From: Roger Spencer
Sent: 12 February 2018 11:35
To: Richard Temple
Subject: FW: Ref Planning Application FP/268/17/PL

PROJECT Gull Point Suites - On the Beach
TITLE Typical Sections
SCALE 1 : 100
DATE 20/09/17
DRG NO IBA/480/09
REVISIONS

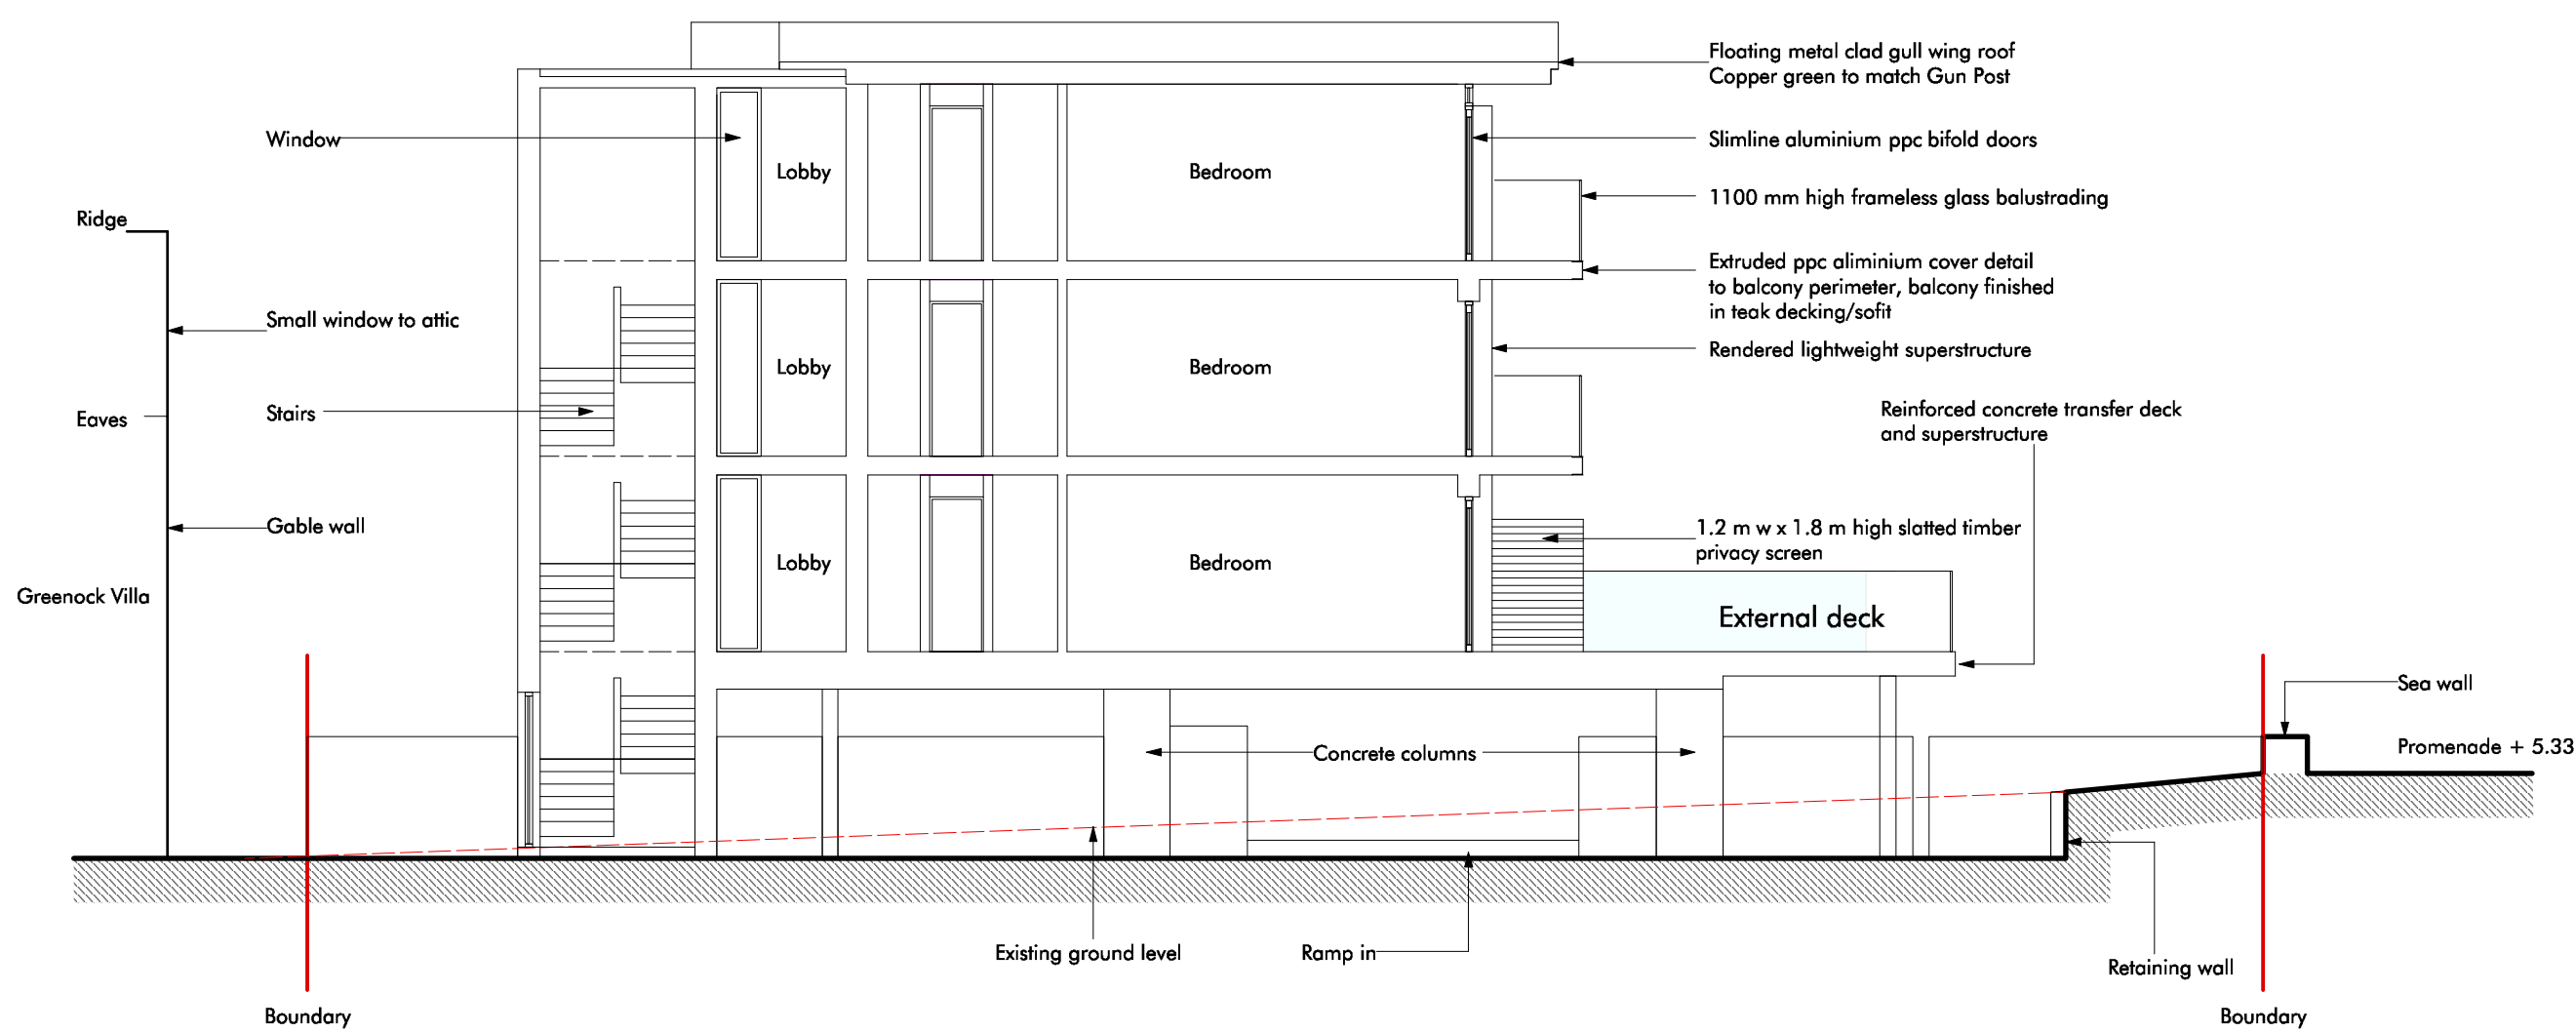
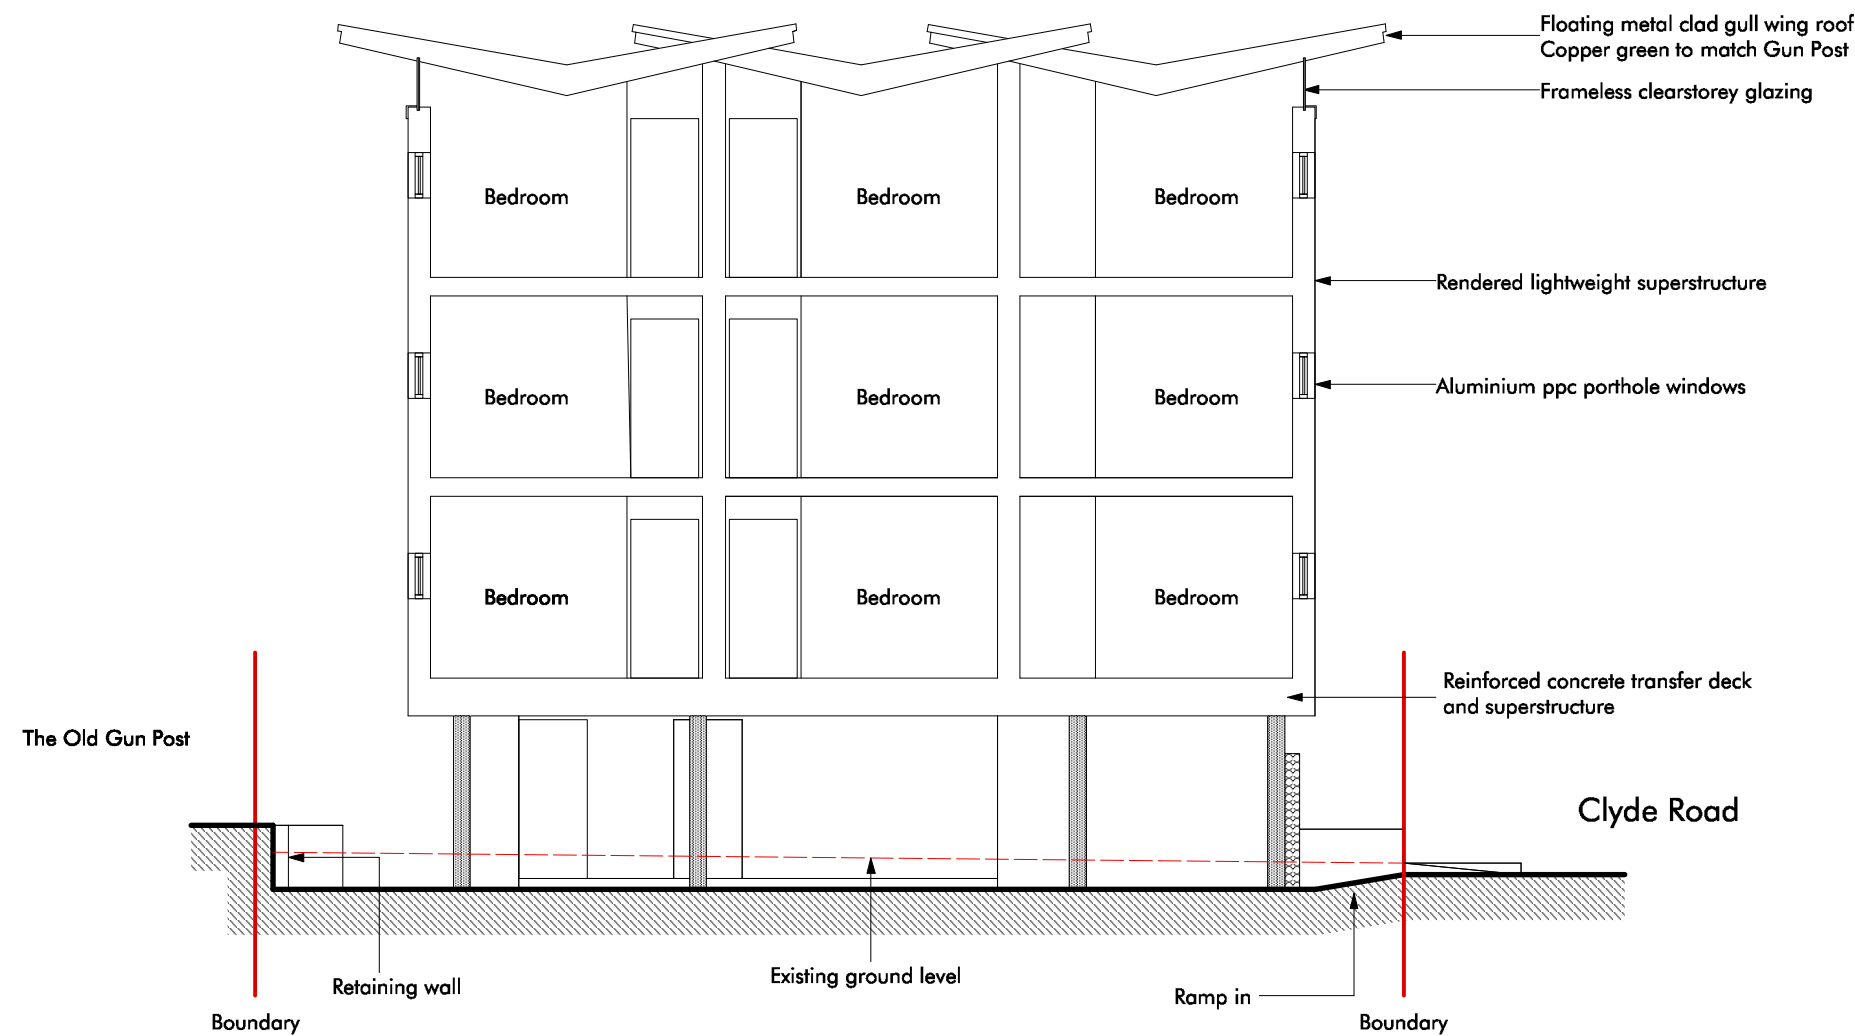
I will leave it to Richard Temple to decide whether or not the main set of drawings (inc. the section through the site) needs to be revised to reflect this detail.

Whilst these references allude to the proposed low timber wall, they do not give sufficient importance, in my opinion, to the job of keeping the sea out. I would have expected to have seen the wall shown in both of your Elevations drawings as well as the Sections drawing (unless that is it is concealed by the red boundary line!).
